**KIRKLEES METROPOLITAN COUNCIL
INVESTMENT & REGENERATION SERVICE**

DELEGATED DECISION TO DETERMINE PLANNING APPLICATIONS

Reference No:	2024/62/90259/W
Site Address:	83, Keldregate, Bradley, Huddersfield, HD2 1TD
Description:	Erection of single storey side extension and front porch with associated alterations
Recommending Officer:	Joanna Rednall

HOUSEHOLDER DELEGATED REPORT

SHEET
Proposed Sheet 1

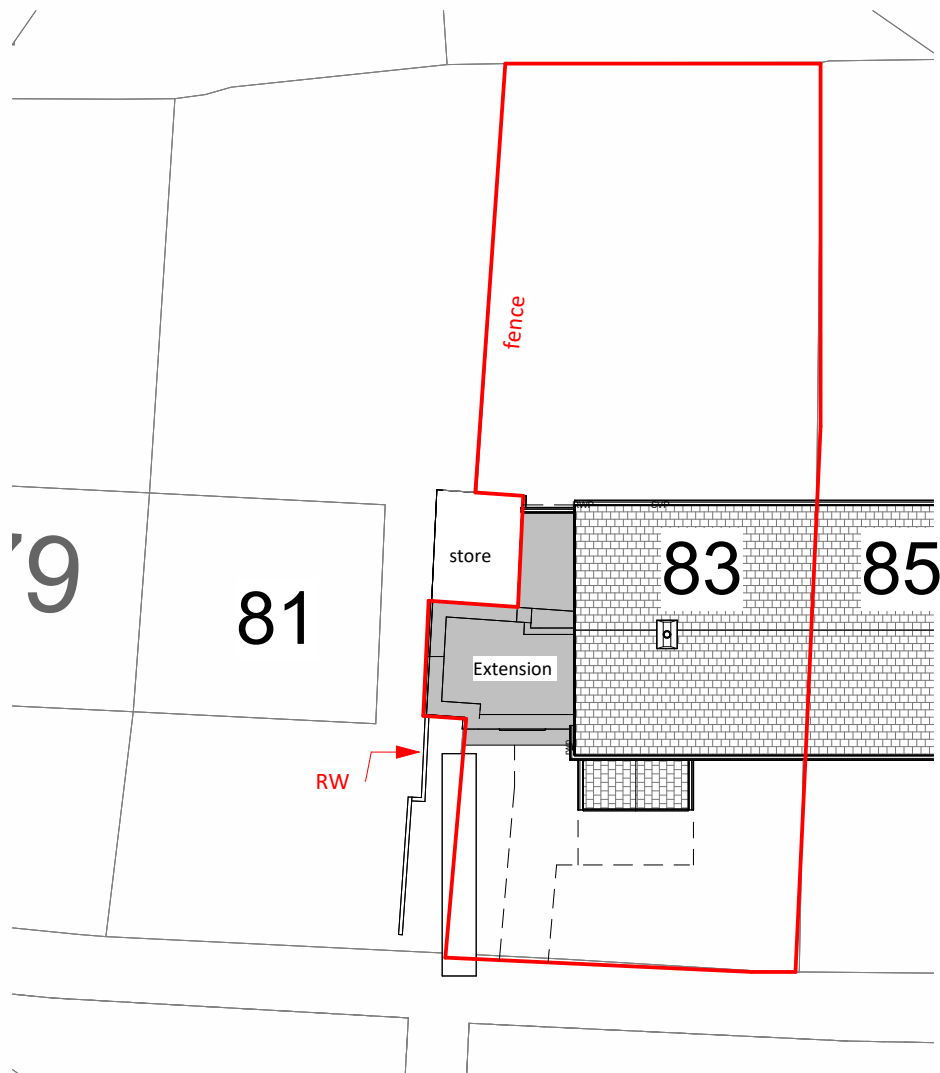
YES / NO	SUMMARY
Negotiations/Amendments during course of application	Yes	Amended plans were sought showing a reduced porch and for the side extension to be set back. Amended plans were received on 19 th March 2024.
Parish/Town Council comments sought	No

Ensure reasonable levels of natural light to the habitable rooms in neighbouring properties	A site visit confirmed a west-facing window within the side elevation of 81, Keldregate, and would directly face the proposed side extension. However, it is likely that this window would serve a hallway, therefore the proposed development would meet this criteria.	
Positioning windows to minimise or avoid any potential overlook into neighbouring gardens	There would be no windows directly facing any neighbouring gardens.	
Single storey side extensions should:		
not extend more than two thirds of the width of the original house	The extension would not extend more than two thirds of the width of the original dwelling.	
not exceed a height of 4 metres	The total height would not exceed 4 metres.	
be set back at least 500mm from the original building line to allow for a visual break	Following amendments, the extension would be set back 500mm from the original building line.

The main body of the application dwelling would prevent any impact from the side extension, however the front porch would have a modest impact. The front extension extends ~1.6 metres from the front elevation of the application property, but is separated by No 85 by ~4 metres. Such a level of separation is considered sufficient to ensure that there is no detrimental overshadowing or overbearing impact on this neighbour.

Pursuant to article 35 (2) of the Town and Country Planning (Development Management Procedure) Order 2015 and guidance in the National Planning Policy Framework, the Local Authority have, where possible, made a pre-application advice service available, complied with the Kirklees Development Management Charter 2015 and otherwise actively engaged with the applicant in dealing with the application. Amended plans were sought showing a reduced porch and for the side extension to be set back. Amended plans were received on 19th March 2024.

SHEET
Proposed Sheet 2

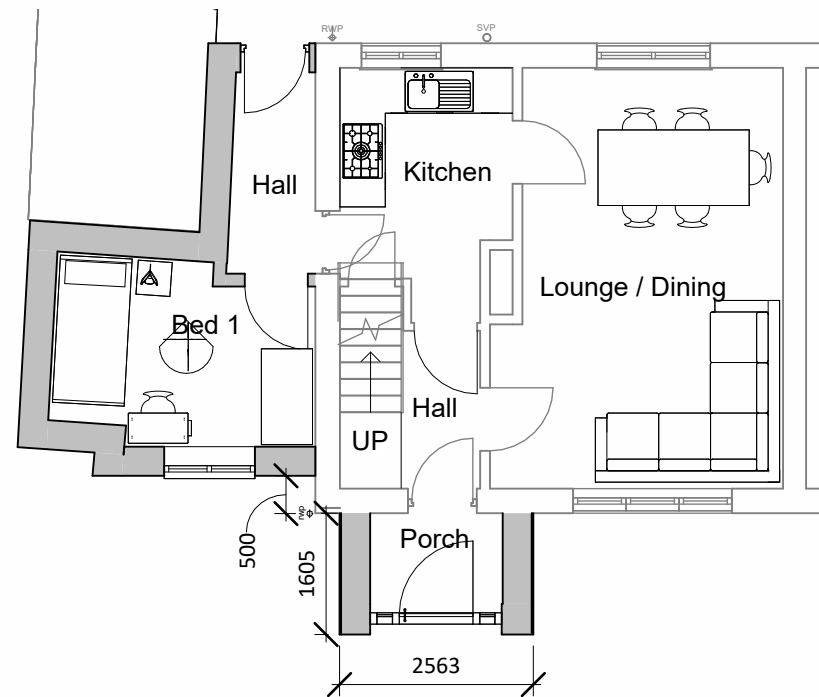
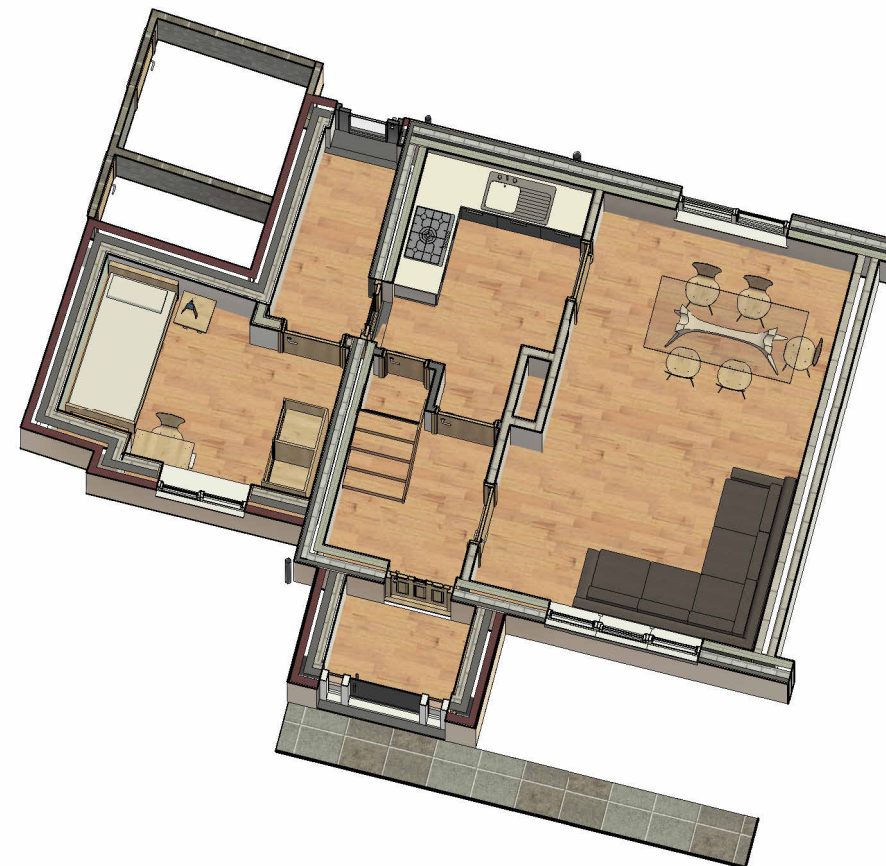
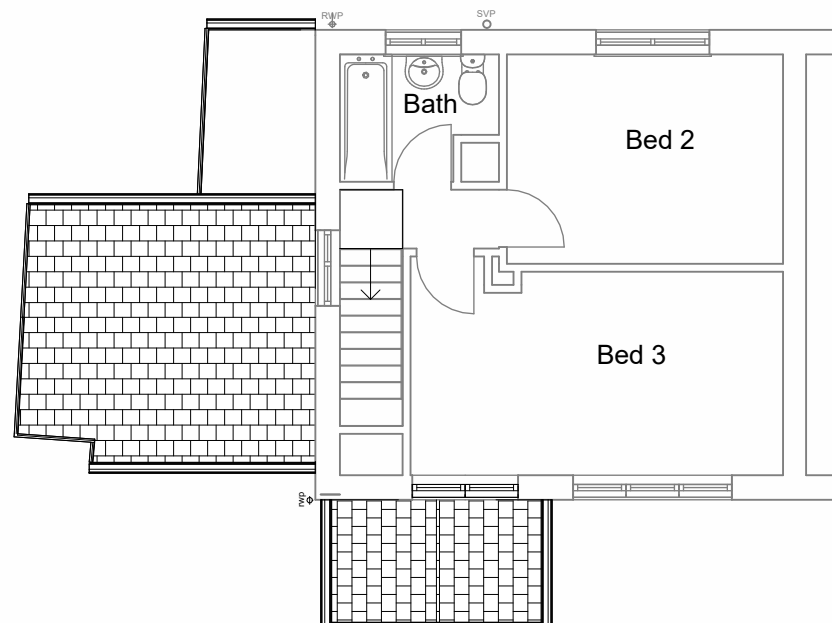
The side extension would have an irregular shape due to extending into the detached store of the neighbouring property. The existing outbuilding structure is shared between two properties. The total side projection would be ~4 metres with the rear ~2.5 metres projecting ~1.5 metres from the side elevation of the original dwelling.

Internally, the extension would provide an additional bedroom and a hall.

As part of the works, a front (north-east facing) window is proposed on the first floor, and would serve a bedroom.

SHEET
Proposed Sheet 3

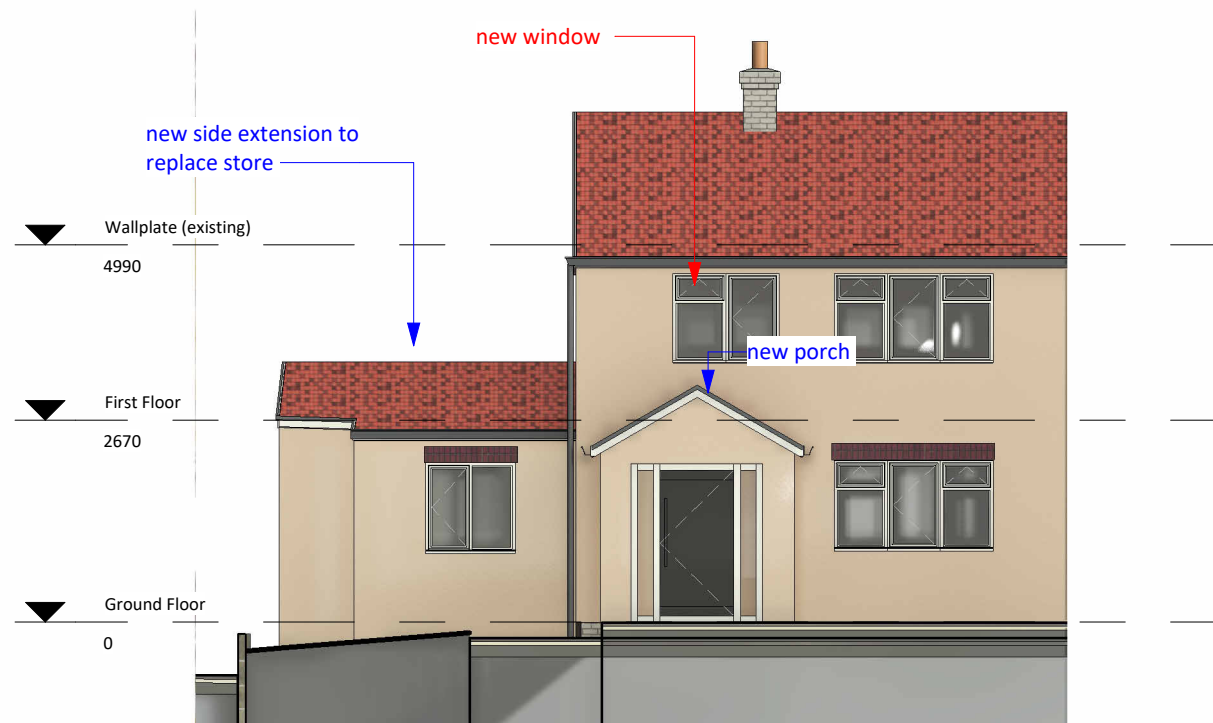
The exterior walls would be faced with render and the roofs would be gable in style to match the existing dwelling.

Single storey front extensions permitted where:		
The house is set well back from the pavement or is well screened	The house is set back ~8 metres from the pavement.	
The extension is small, subservient to the original building, well-designed and would not harm the character of the original house or the area	The porch has a minimal projection of ~1.6 metres, and the dwelling is well set back from the pavement. The porch is designed as such with a roof style to adequately harmonise with the host dwelling with matching

The development would change the roof form to be gable in style, increasing the total height by approximately 2 metres. A site visit confirmed a ground floor window facing the elevation property, however this likely serves a hallway and not a habitable room. In addition, any possible overshadowing/overbearing would only impact a path along the side of No 81, and would not harm the main amenity space of the dwelling.
